From: Laura Gibbons
Sent: 23 June 2020 13:56
To: Planning.Responses [REDACTED]
Cc: Simon Davis [REDACTED]
Subject: N of Summer Lane P/35/20/DOC & P/37/20/DOC

We have the following comments regarding the revised surface water drainage details submitted for P/35/20/DOC and P/37/DOC.

Further ADC drainage comments. N.B. Strike throughs indicate comments that have been resolved.

Headwall SW-9

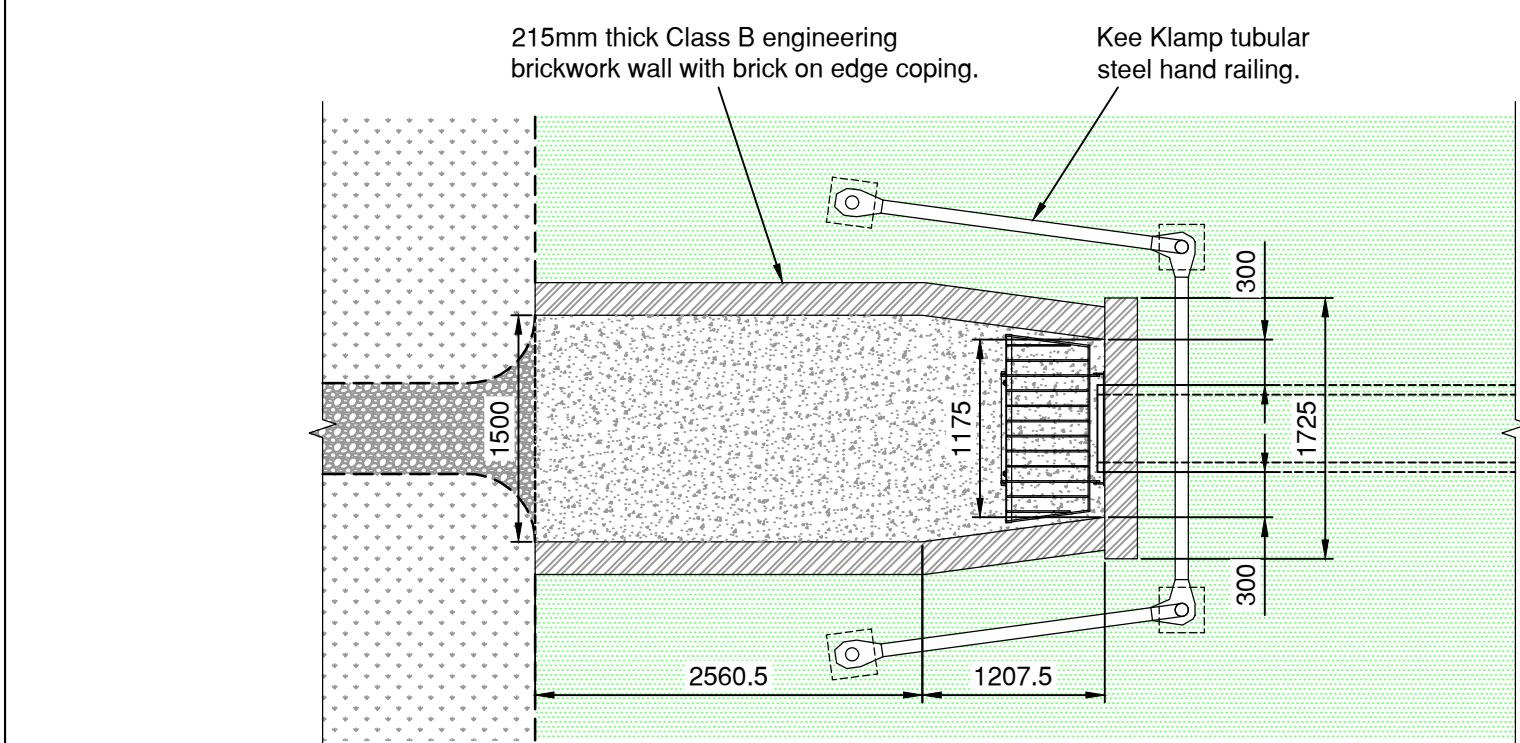
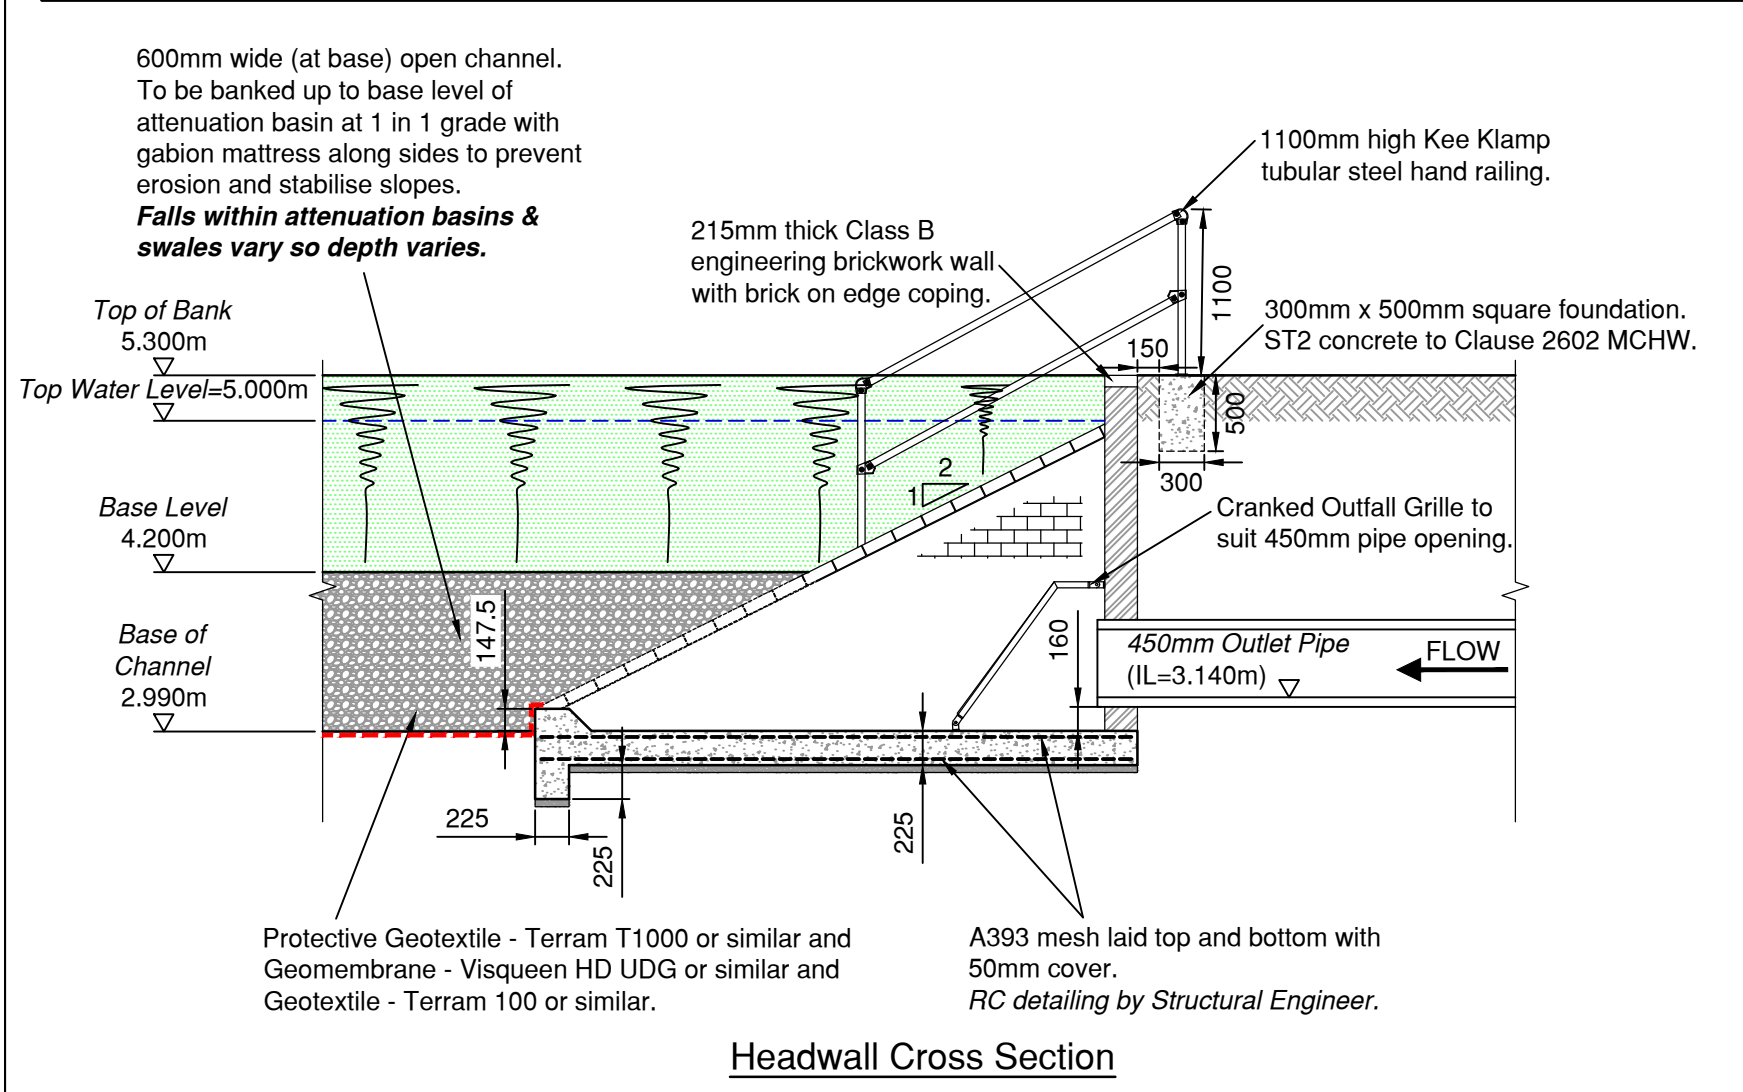
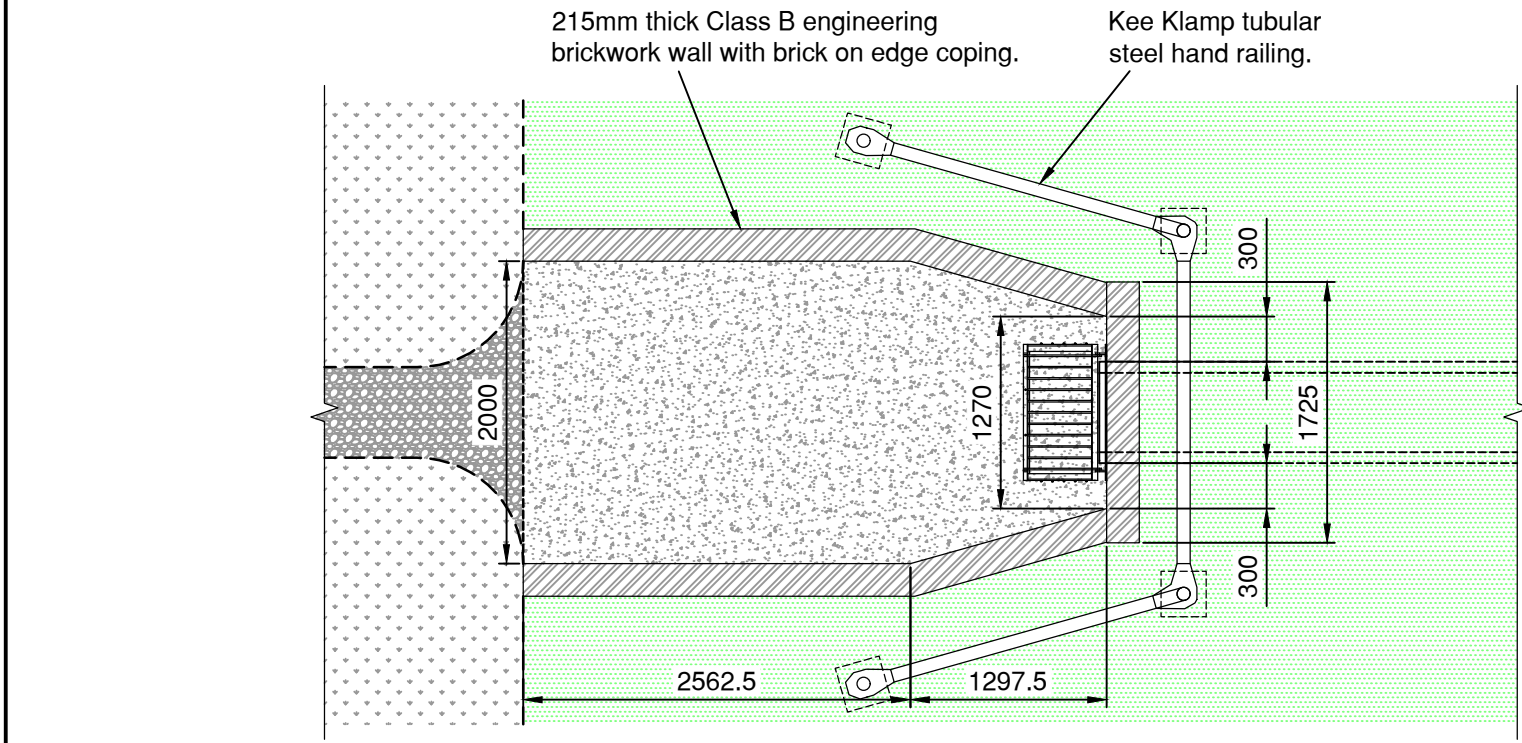
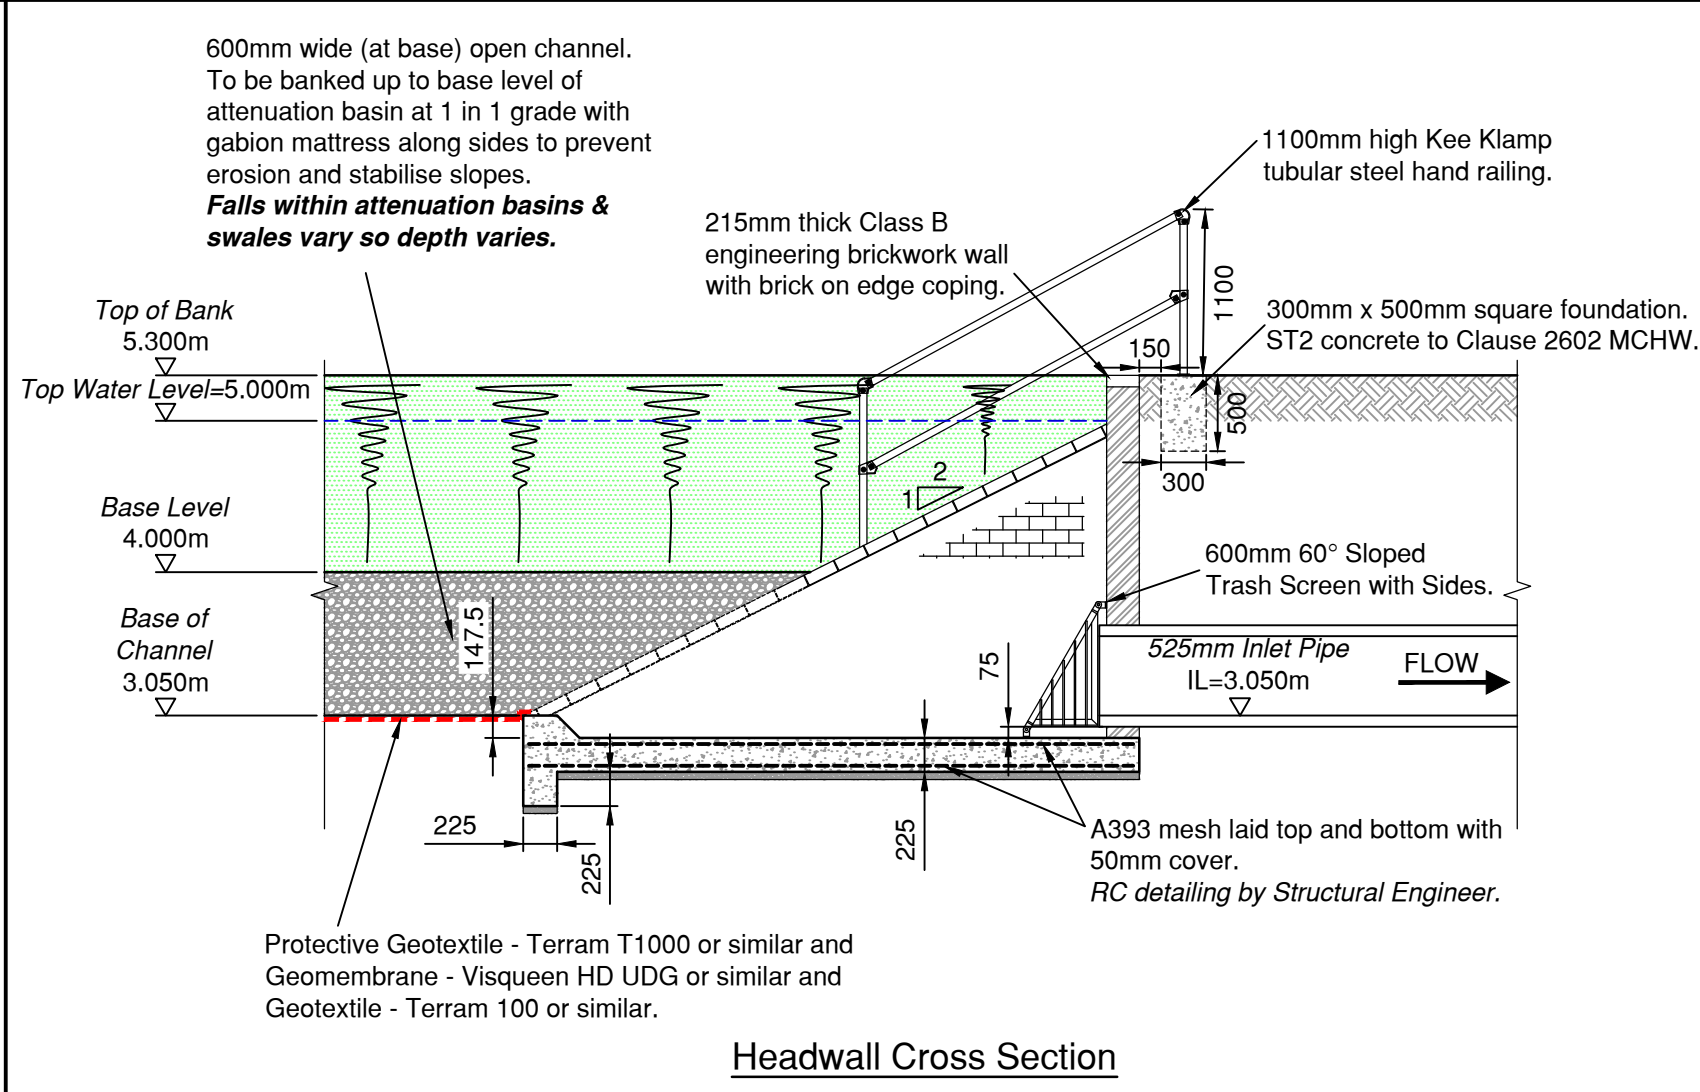
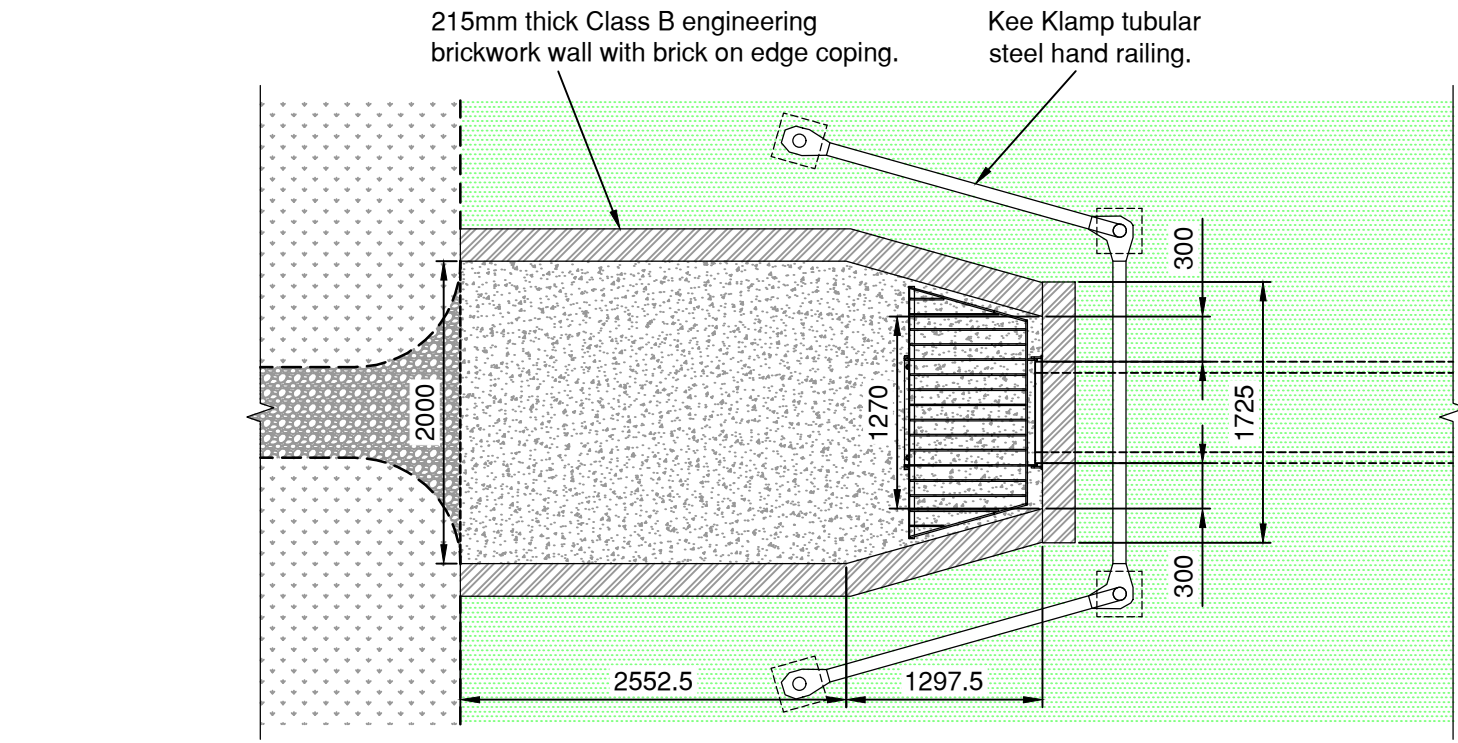
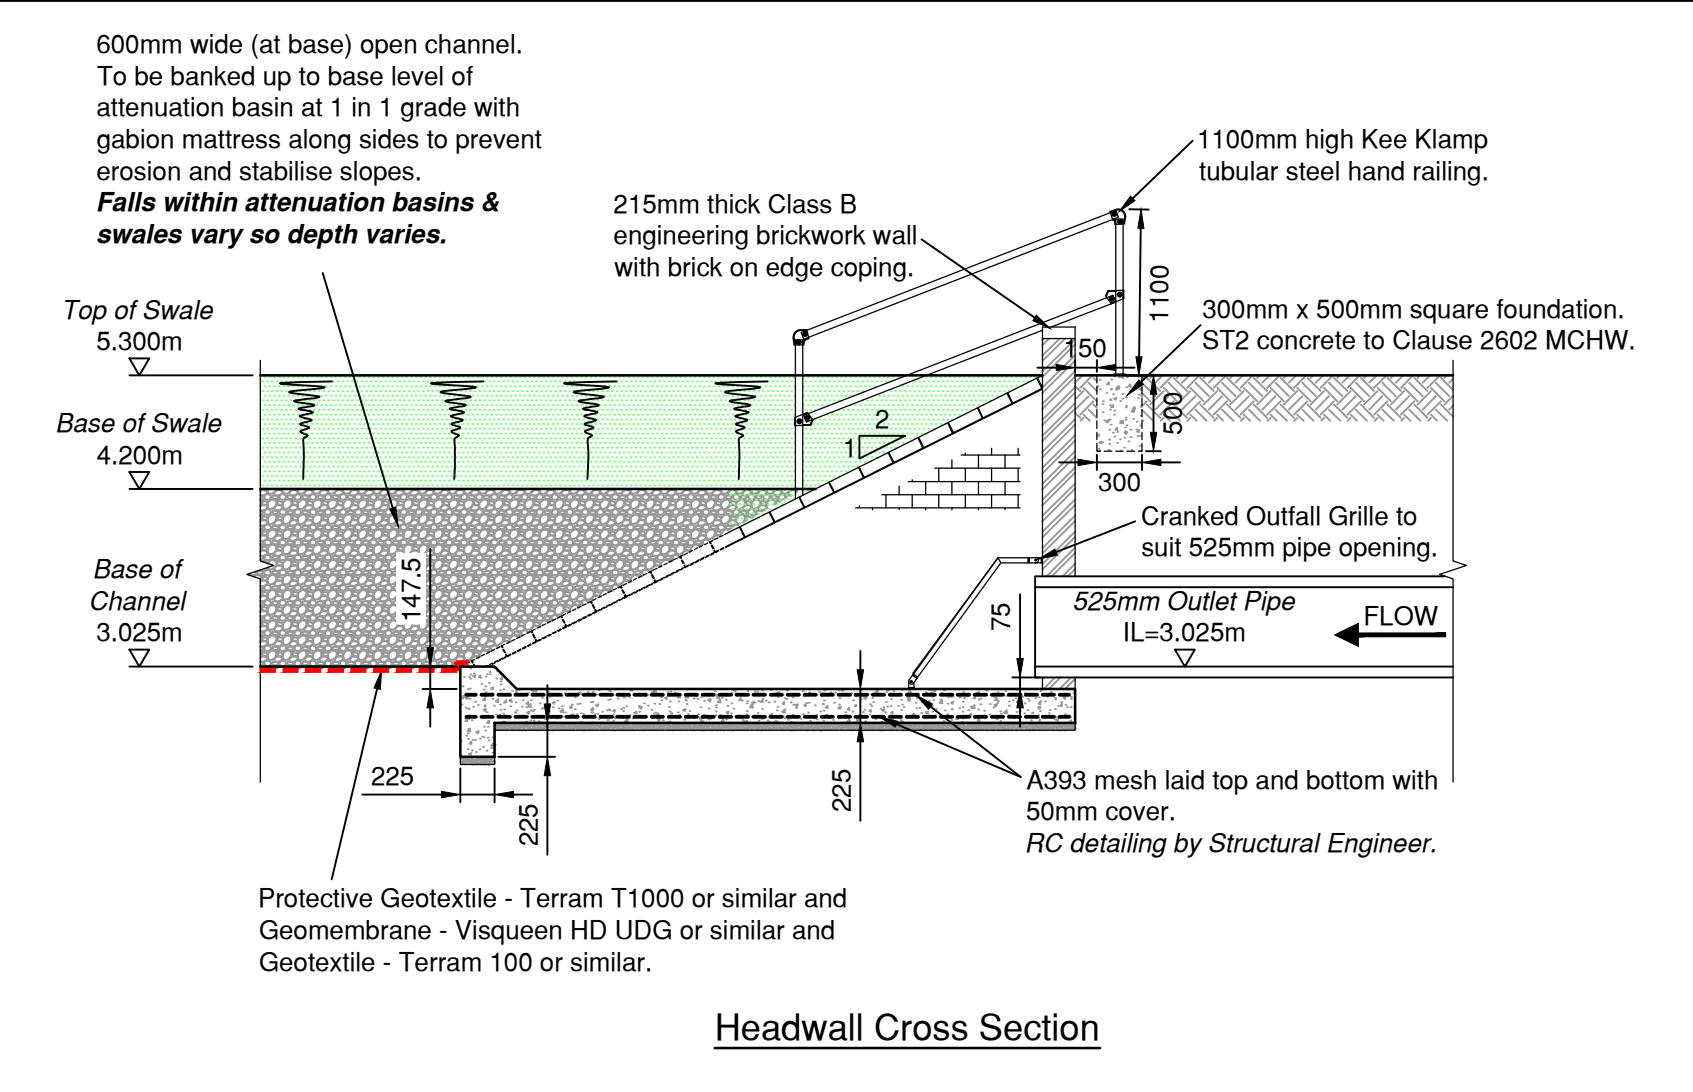
9. All headwall grilles to be cranked as opposed to be flat or just sloped faced. Headwalls SW-4, SW-5, SW-9, SW-13, SW-29 and SW-32 updated to cranked grilles. Headwall SW-9 cross-section grille not shown (layer not visible?), please ensure this is visible on drawings. Please remove note to Sewers for Adoption, please add construction detail showing typical grille, ensuring that bar spacing, materials, point of lock are shown. Headwall SW-9 cranked grille now shown. Typical grille construction detail added indicating Material, centre spacing and point of lock added.
